WEST SUSSEX COUNTY COUNCIL CONSULTATION

TO:	Arun District Council FAO: Zac Denton
FROM:	WSCC - Highways Authority
DATE:	8 June 2020
LOCATION:	54 Torton Hill Road Arundel BN18 9HH
SUBJECT:	AB/23/20/HH First floor side/rear extension, porch and canopy to front, single storey rear extension, two storey side/rear extension, external refurbishment to all principle elevations & new permeable paving to drive (resubmission of AB/117/19/HH). An amended plan received.
DATE OF SITE VISIT:	n/a
RECOMMENDATION:	Advice
S106 CONTRIBUTION TOTAL:	n/a

Proposed Site Plan

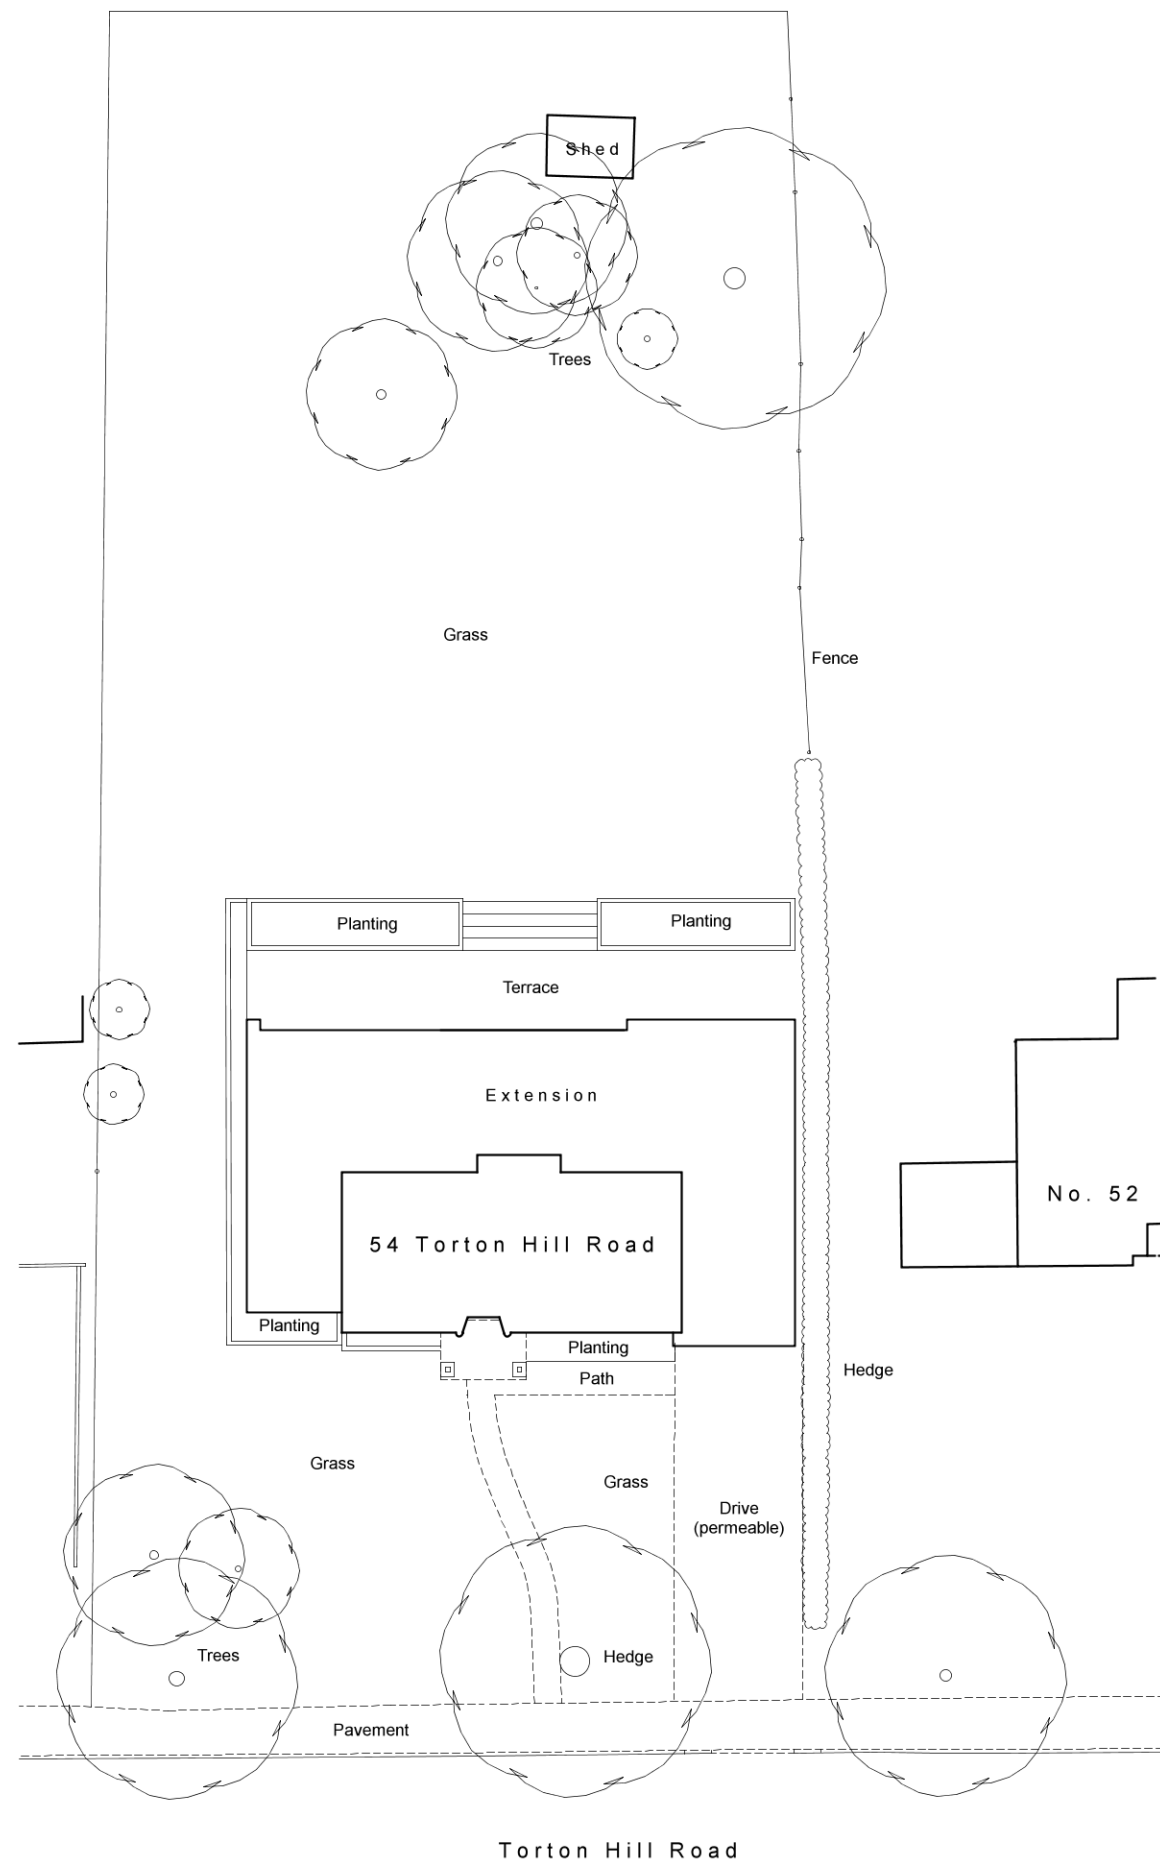
The LHA advises the applicant to widen the Vehicle Crossover (VCO) to accommodate the new hardstanding's width. This should show at least 1 metre both sides to allow a vehicle to enter and exit the parking area without fouling upon the kerb edge.

- Bay Parking Spaces – Measures 2.4 x 4.8 metres,

For the LHA to consider bay parking spaces towards the parking provision of the site they must first measure 2.4 x 4.8 metres (as per MfS guidance). The applicant has demonstrated such. As a result, the LHA would consider the parking spaces to provide a provision of two spaces.
